CDR21013-R1-GEC.pdf Markup Summary

Add: CDR2113

**STERLING RANCH DEVELOPMENT
BRIARGATE BOULEVARD BRIDGE GRADING & EROSION CONTROL PLANS
GRADING AND EROSION CONTROL PLAN
EL PASO COUNTY, COLORADO**

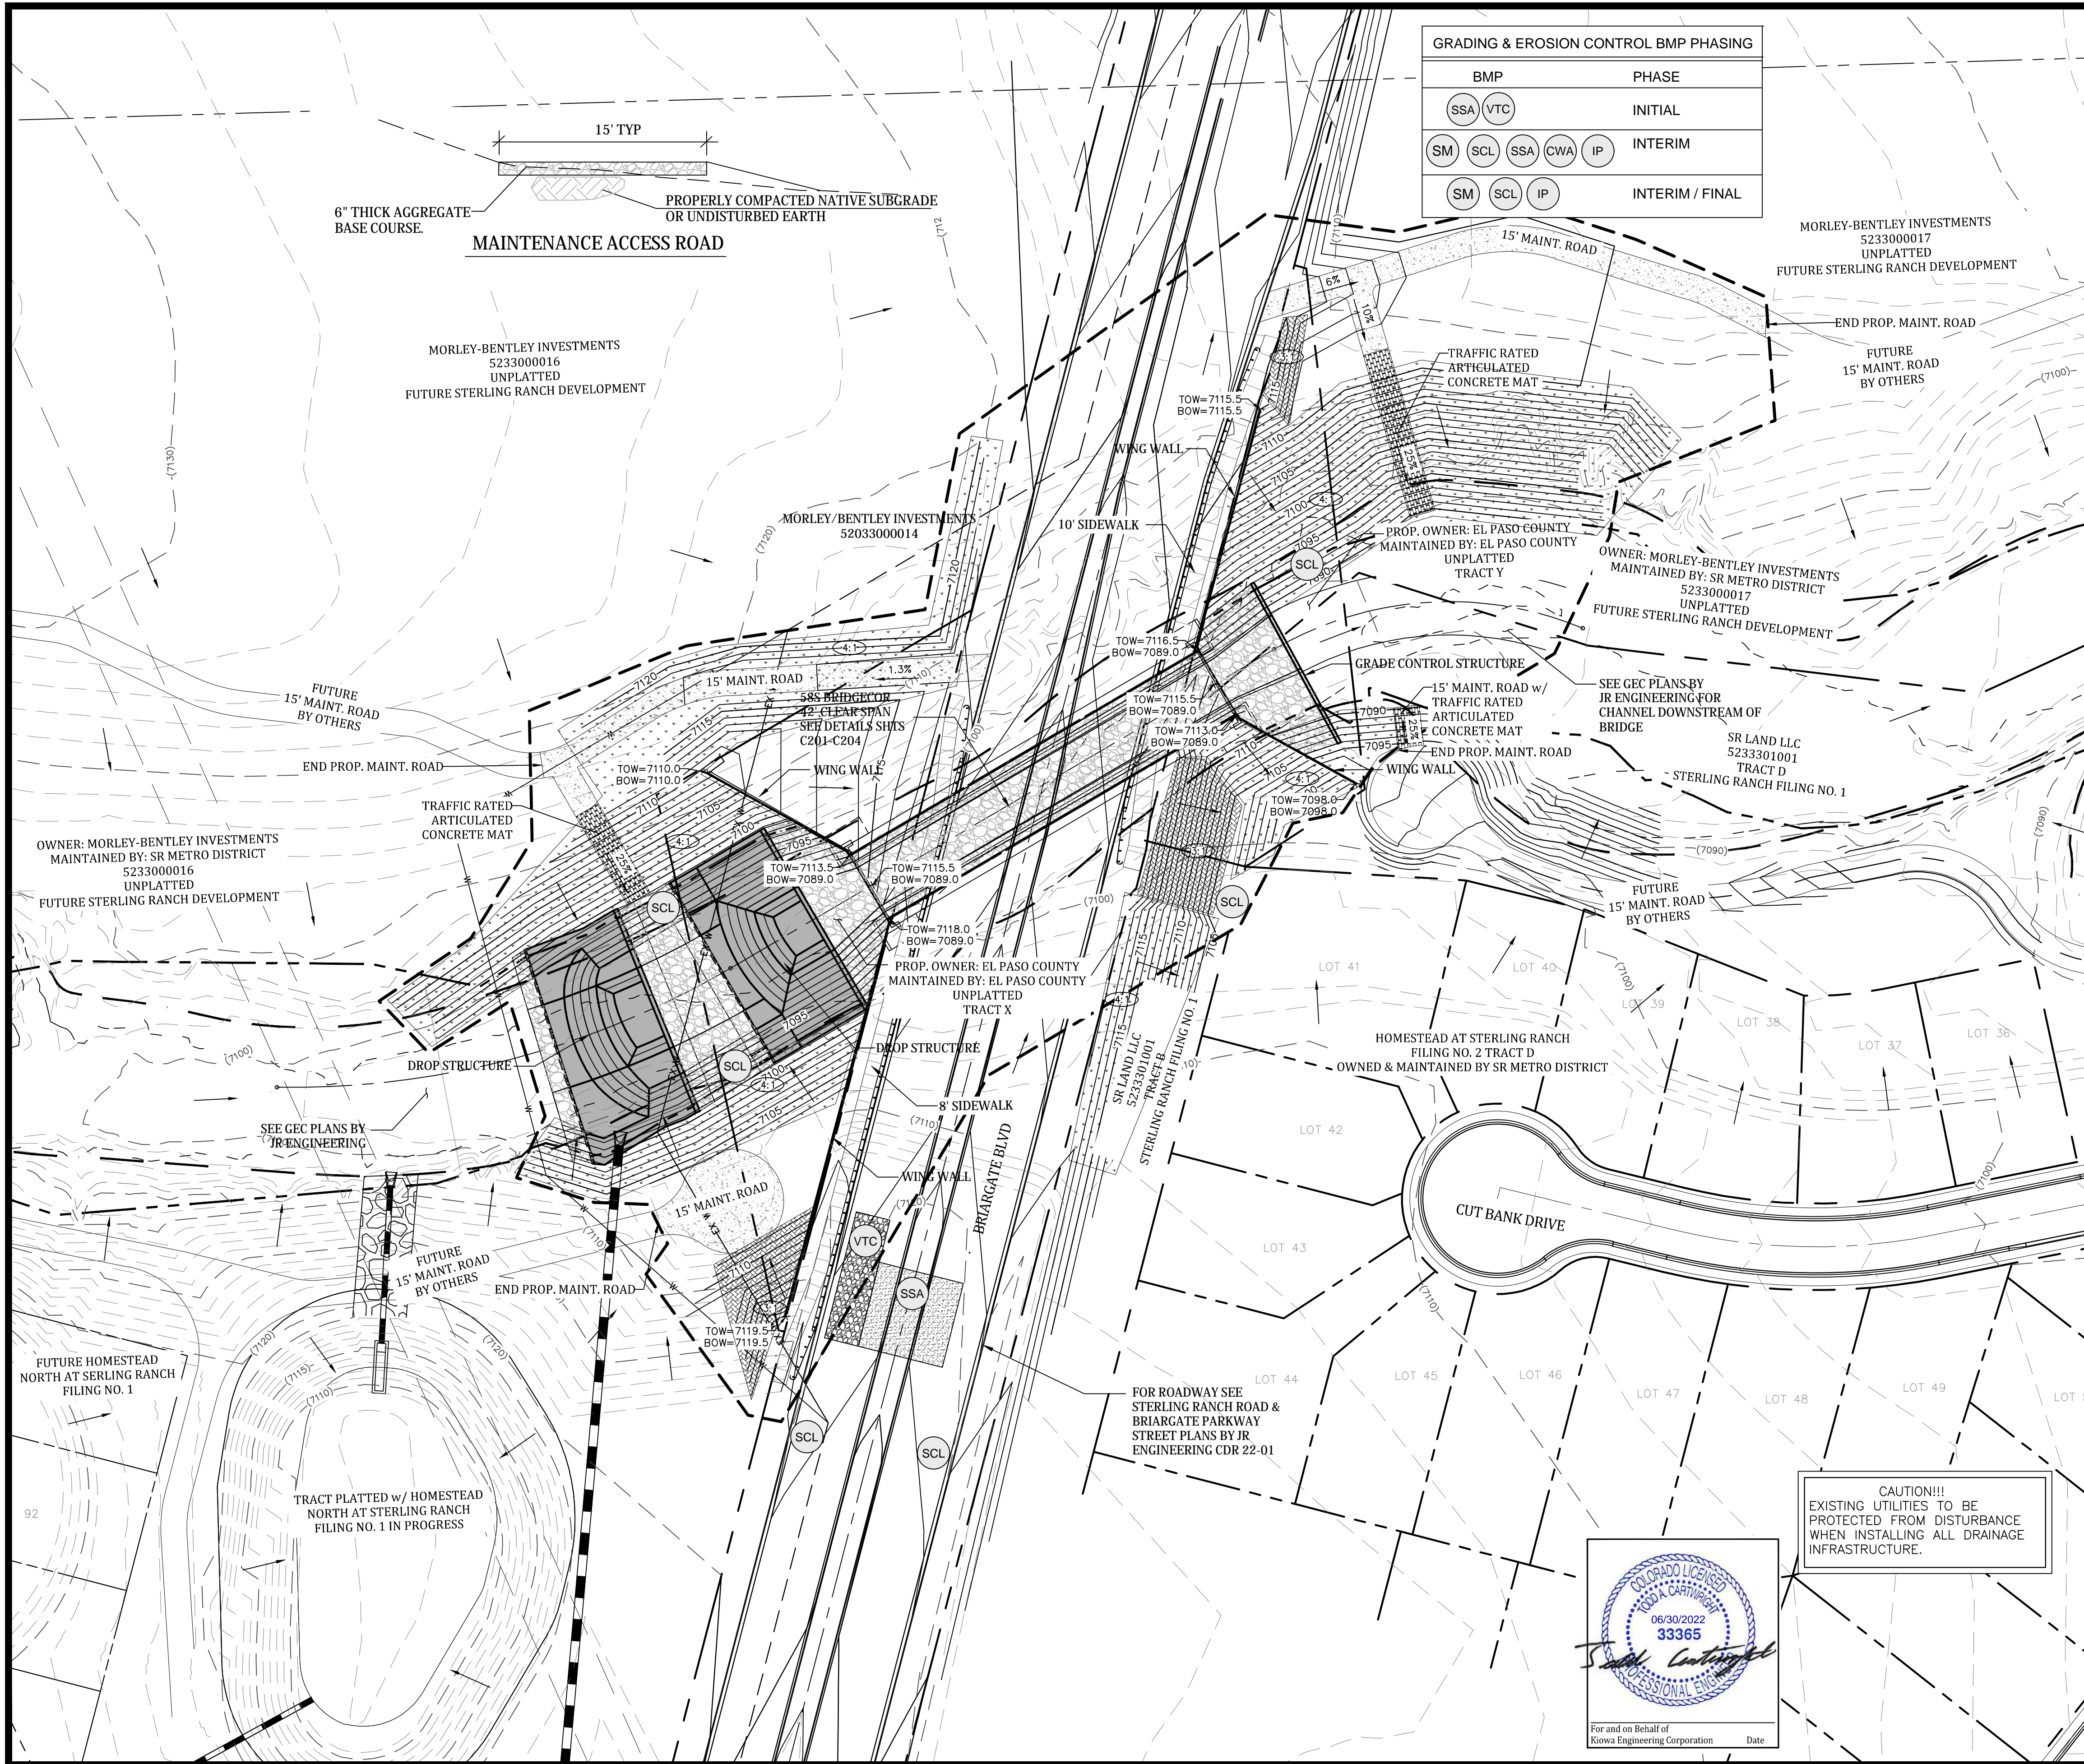
Linetype is missing for limits of grading on Legend and plans.

- Checklist Item "b" - label some of the streets and subdivisions shown on this sheet.
- Checklist Item "p" - delineate areas of cut/fill. A summarizing note is acceptable.

add drainage flow arrows to Legend

- If there is no VTC here (per Note 5 on this sheet), remove this bubble.
- Same for the CWA and SSA bubbles (per Note 1 on this sheet)

label grade of steep slopes. And if 3:1 or greater, label with ECB bubble. Otherwise, if no ECB is to be used here, consider the need for other BMPs like silt fence or sediment control logs.

connect proposed contours to existing.

connect proposed contours to existing.

label where this is located on the plans or remove if not applicable to this project.

label pond

Show locations of SCL and IP on plans.

Show proposed reseeding, blanketing, etc. in the graded channel bottom area

Show riprap
